**KIRKLEES METROPOLITAN COUNCIL
INVESTMENT & REGENERATION SERVICE**

**DELEGATED DECISION TO DETERMINE APPLICATIONS FOR
NON-MATERIAL AMENDMENTS**

Reference No: 2018/NM/90325/W

Site Address: 2, Fernlea Grove, Golcar, Huddersfield, HD7 4HF

SITE	2 Fernlea Grove - Golcar HD7 4HF	SCALE	1:100 @ A3	DATE	20.01.2017
TITLE	Proposed House	DRG NO	FG2		J.A

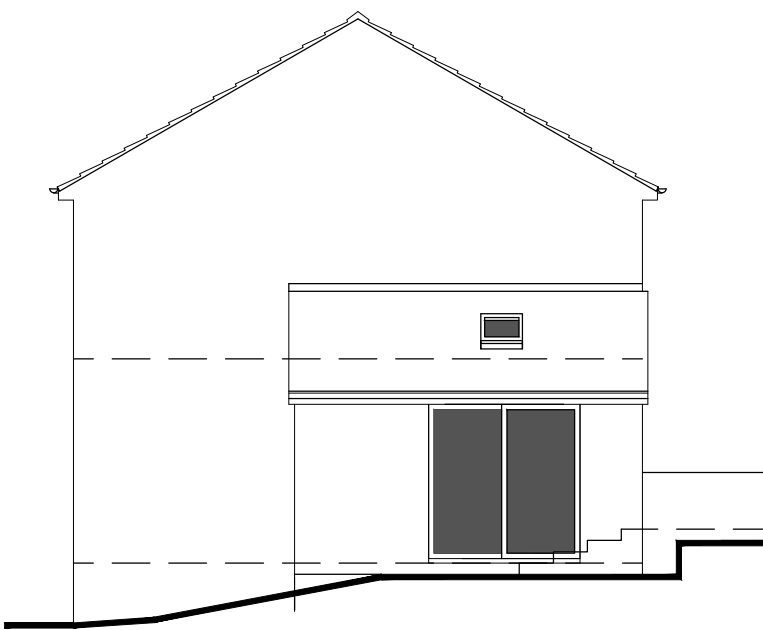
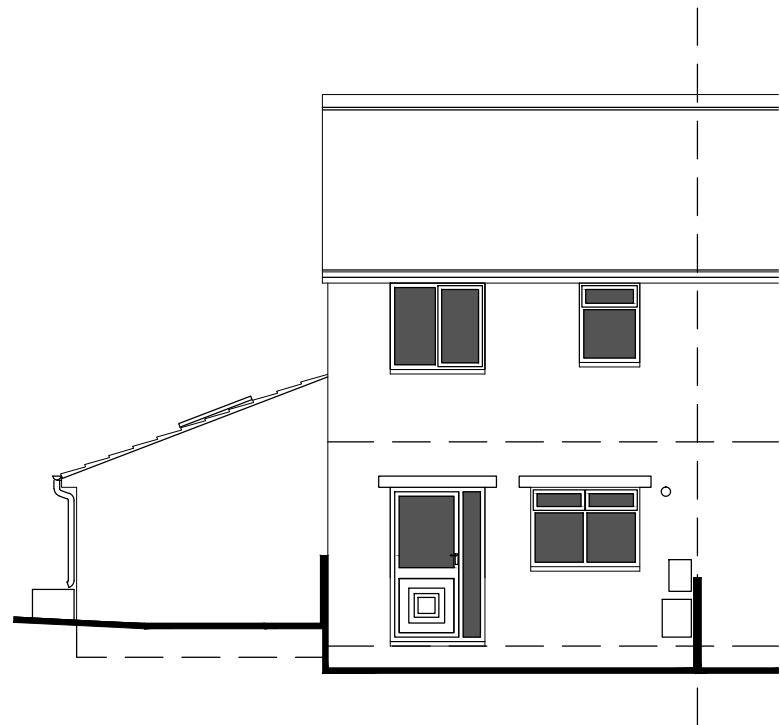
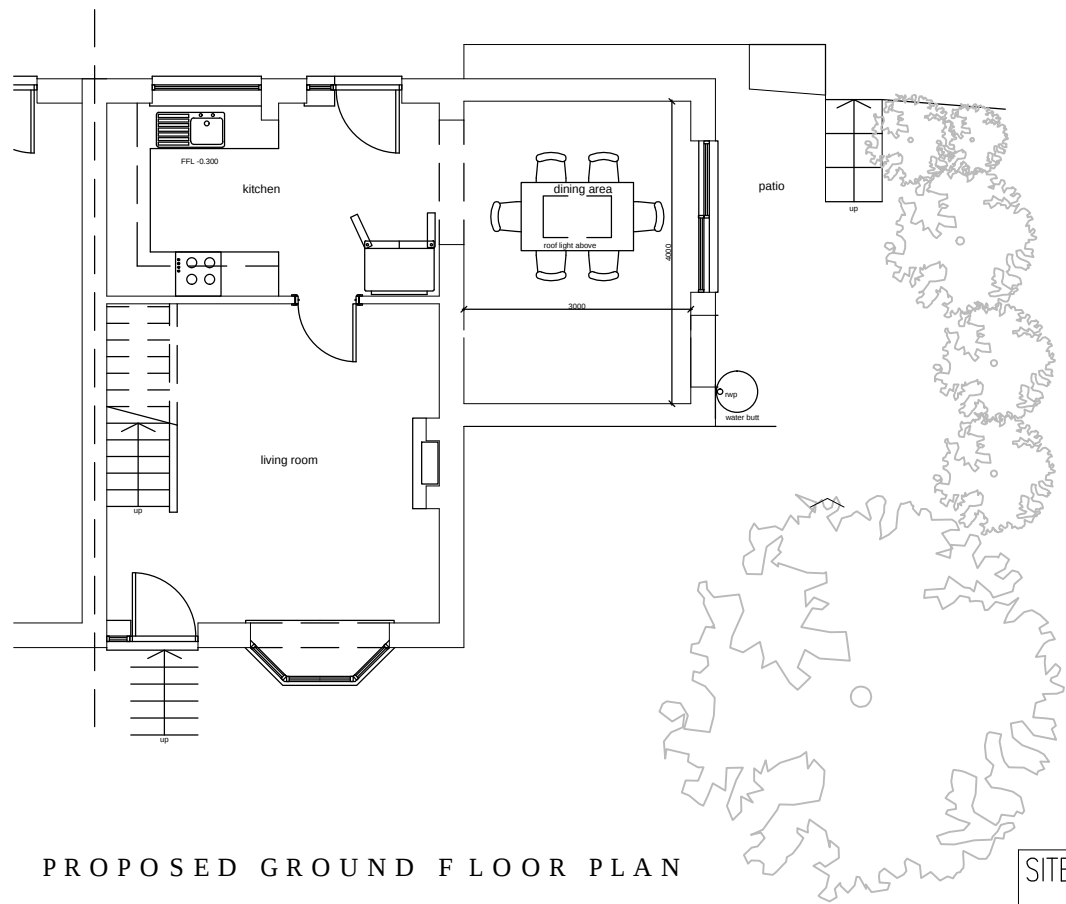
The application has proposed the following as a schedule of alterations to the proposed extension as detailed on the application form and on drawing no.FG2, dated 20/01/2018 and received by Kirklees Council on 31/01/2018:

“[A reduction in] the length of the extension from 6.5m [including] dining room with patio doors and a utility room and door to outside, to 4.6m [including] dining room and patio doors”.

2. The originally approved extension was considered to be acceptable in terms of its impacts upon visual amenity. The new proposal is visually and materially similar to that originally approved and would, by virtue of its reduced scale, slightly lessen the visual impact on the elevations to both the north-east (Station Lane) and the south-east (Fernlea Grove).

On the basis of the above, the proposed changes would be acceptable under the non-material amendment procedure.
